WEST SUSSEX COUNTY COUNCIL CONSULTATION

TO:	Arun District Council FAO: Mr S Davis
FROM:	WSCC - Highways Authority
DATE:	3 August 2020
LOCATION:	Land between 2b and 4 London Road Bognor Regis NEAR PO2
SUBJECT:	BR/131/20/PL Erection of a commercial unit at ground floor level with residential development of 3 no. bedroom flats above. This application is in CIL Zone 3 (Zero Rated) for flats & shop (Zero Rated).
DATE OF SITE VISIT:	n/a
RECOMMENDATION:	Advice
S106 CONTRIBUTION TOTAL:	n/a

PROPOSED FLOOR PLANS

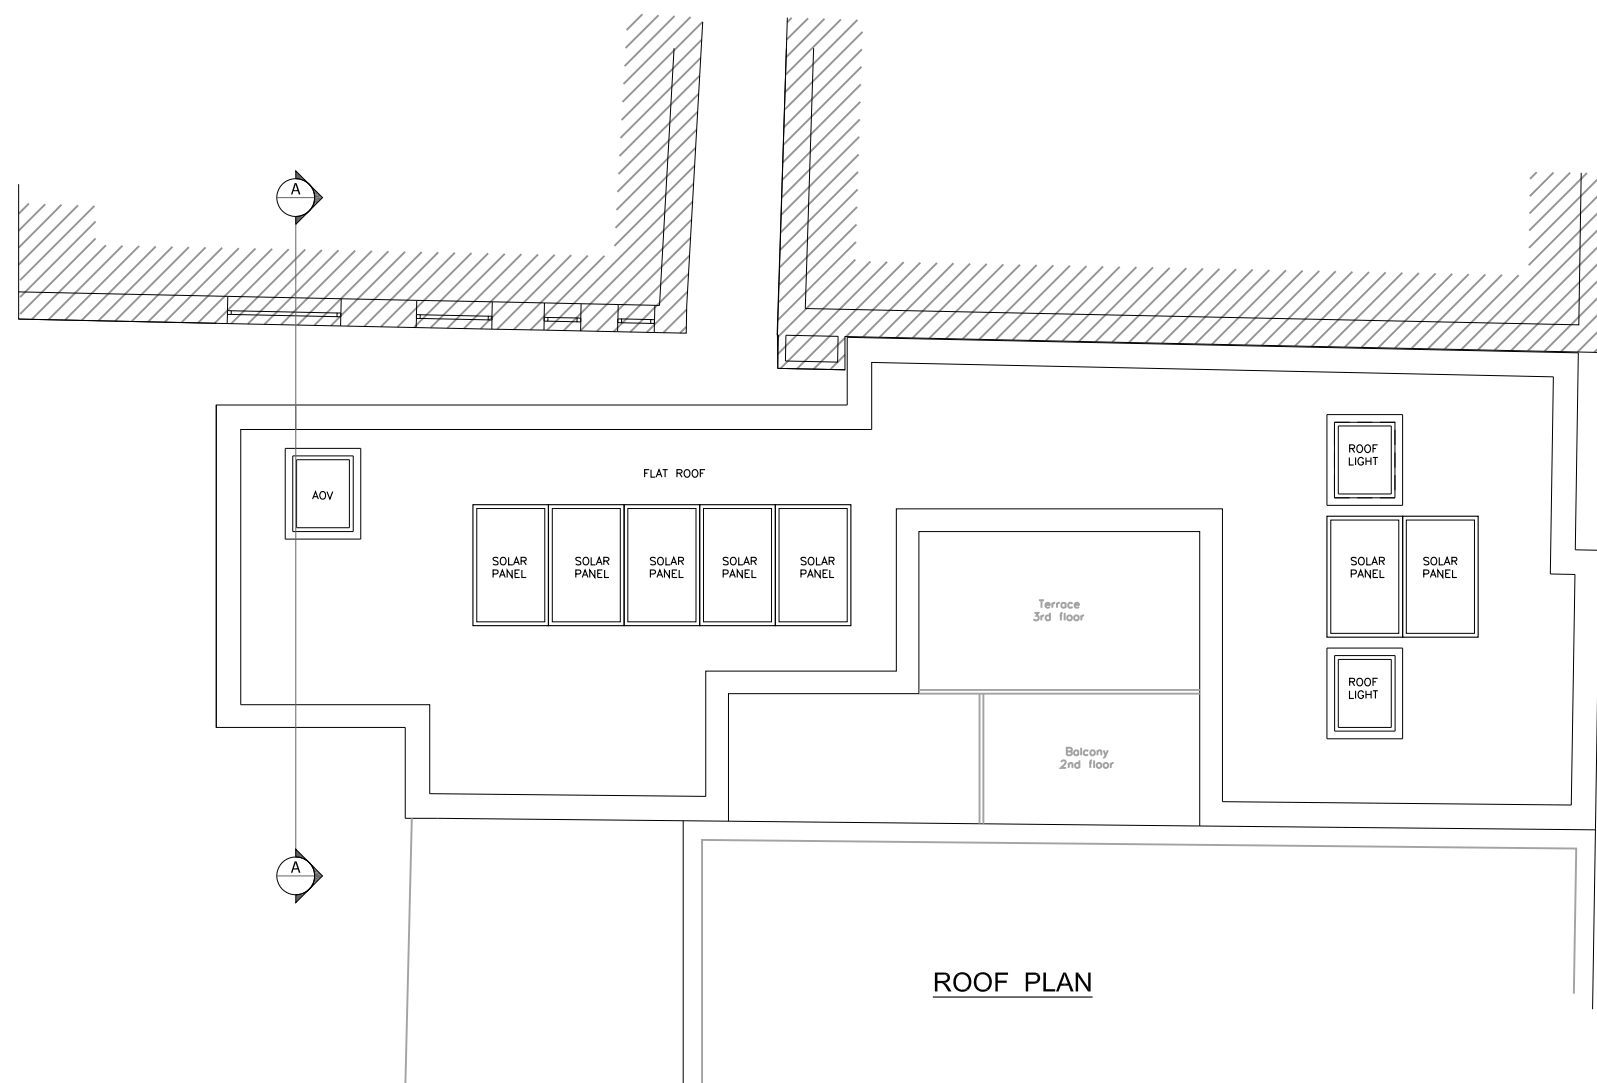
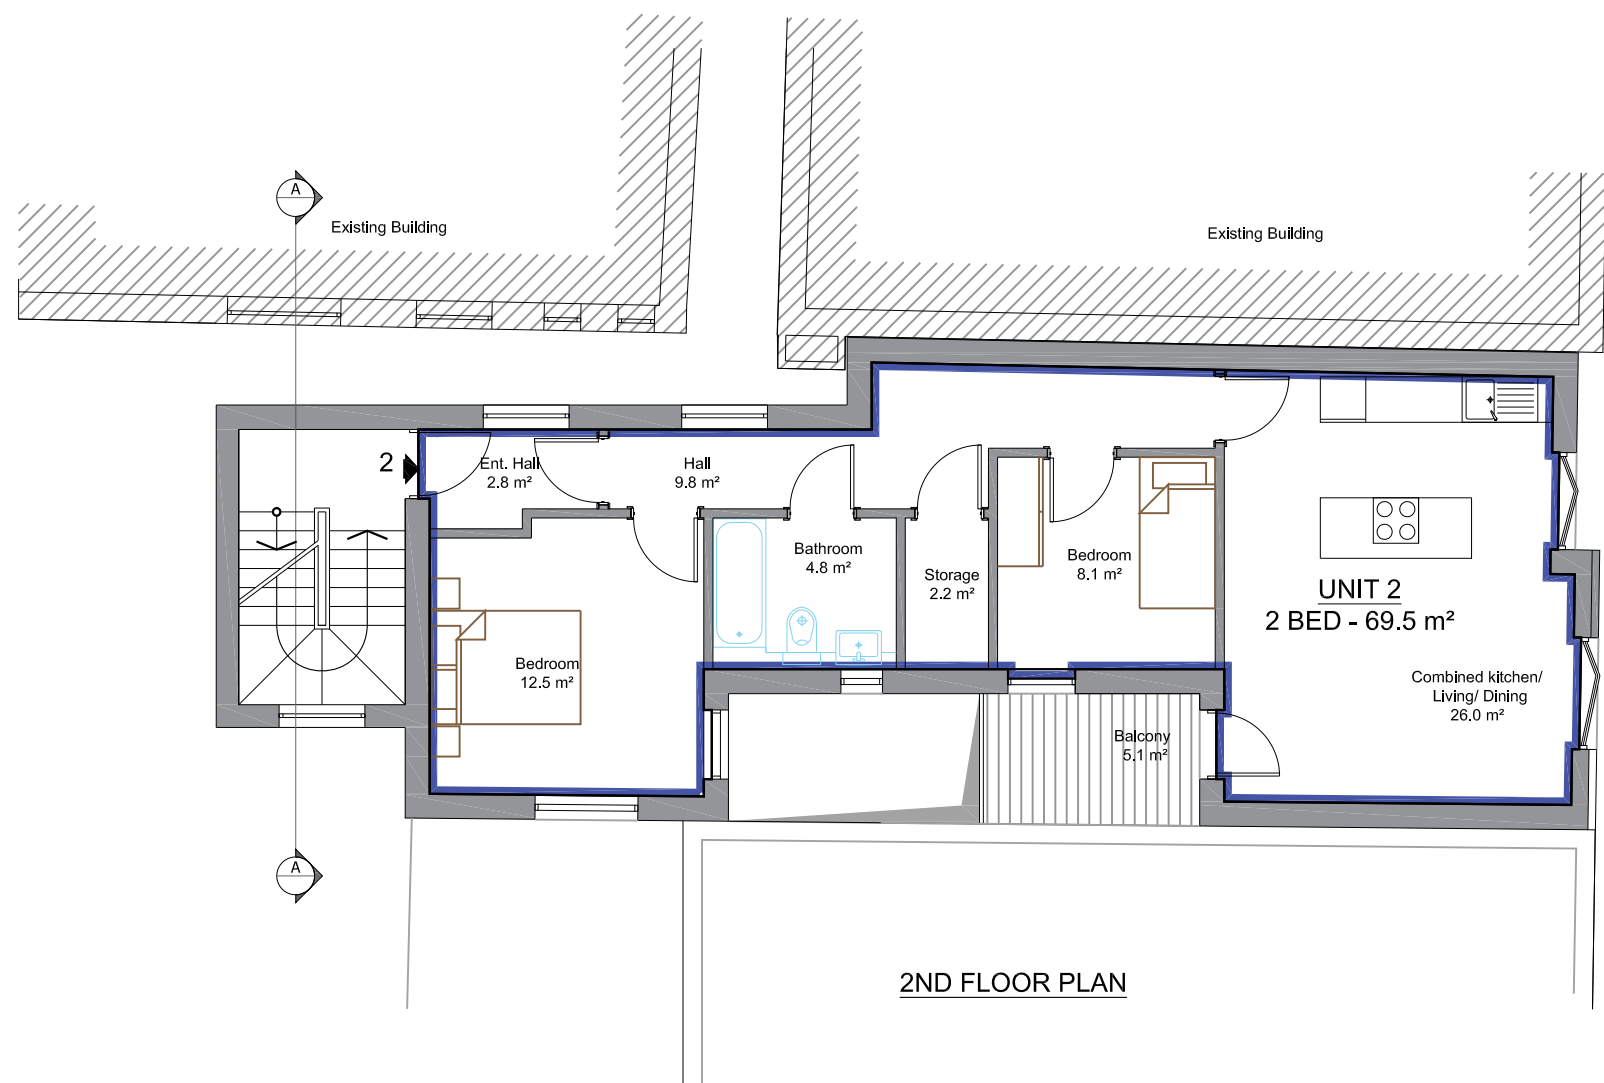
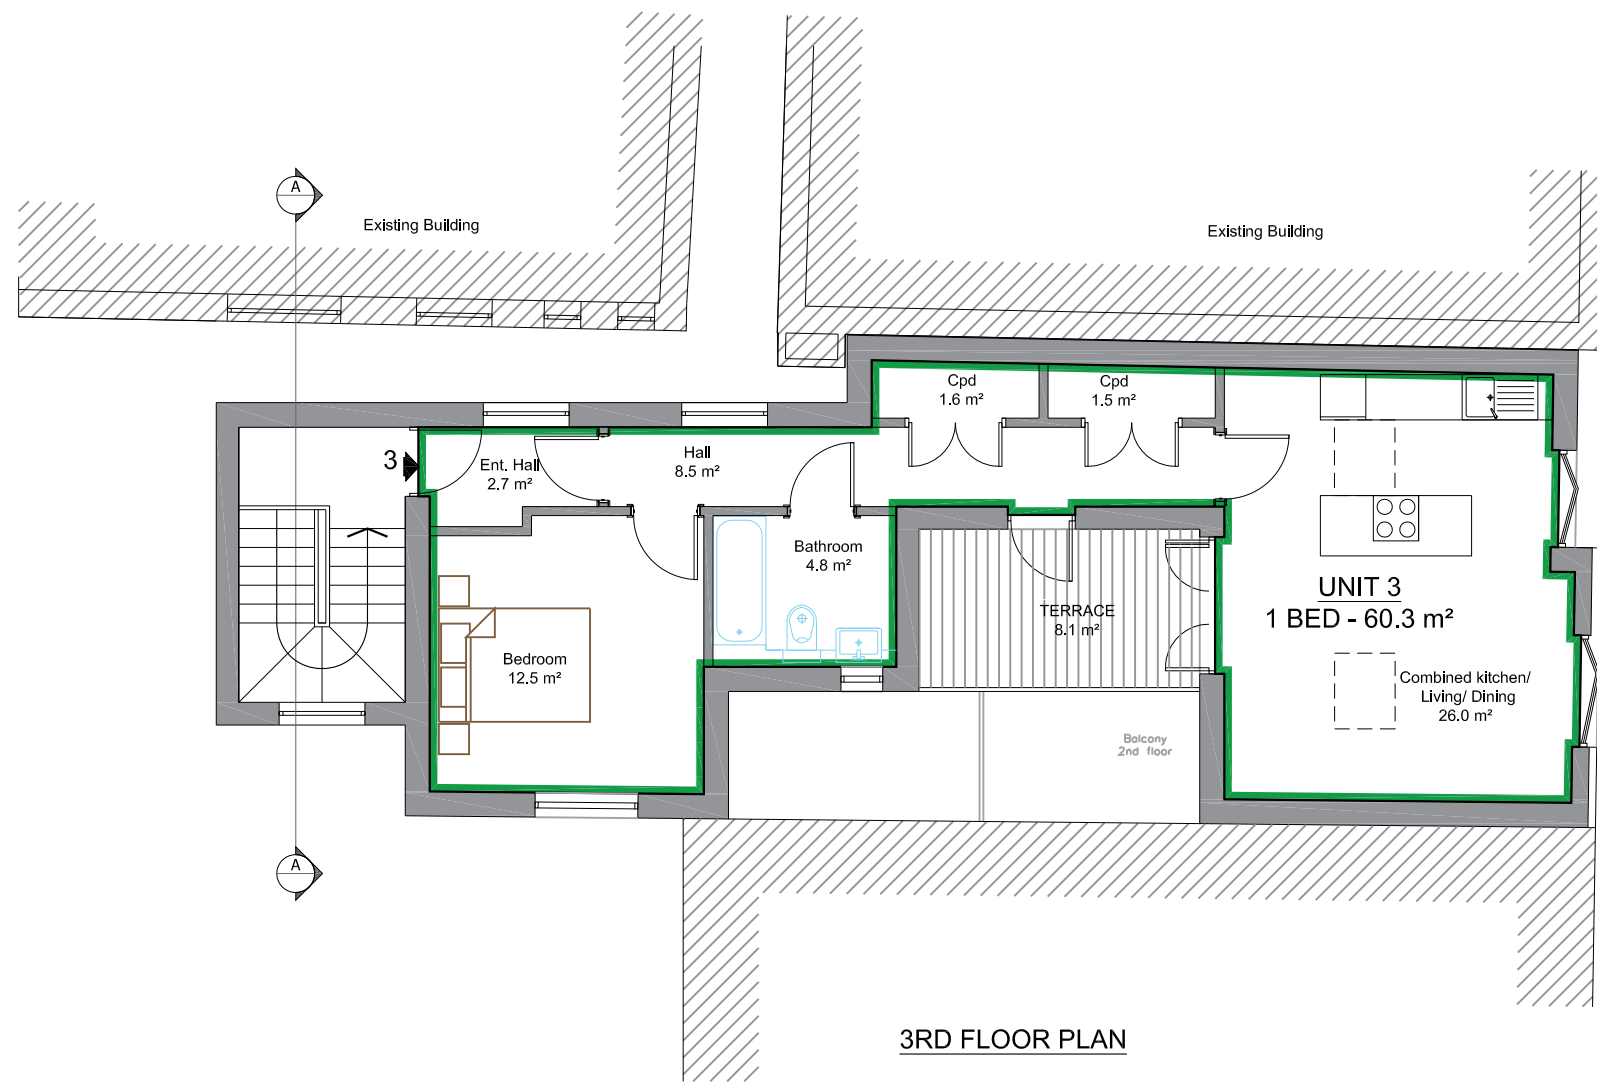
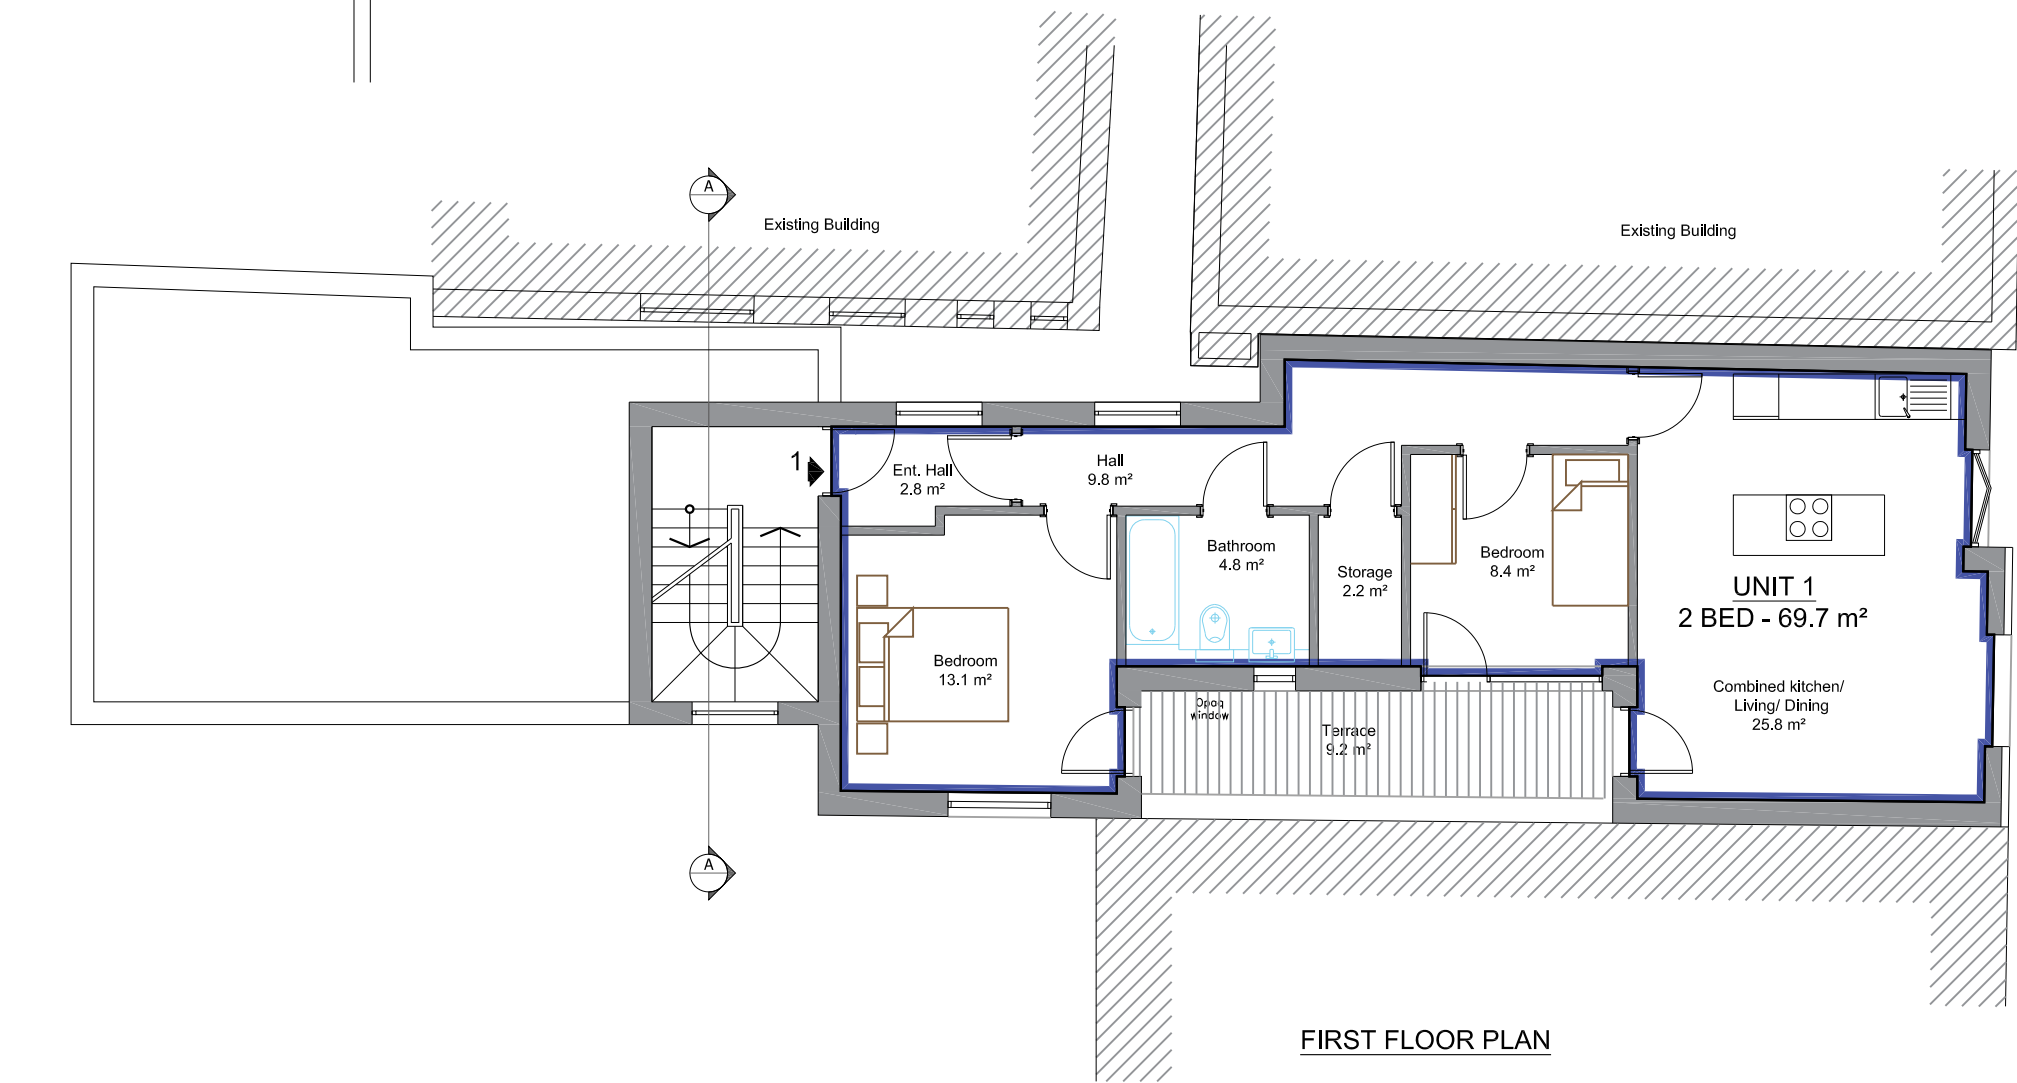
The plans detail a communal 4 cycle parking provision. This provision would be considered in line with Arun Parking Supplementary Planning Document.

No part of the development shall be first occupied until covered and secure cycle parking spaces have been provided in accordance with the approved planning drawings.
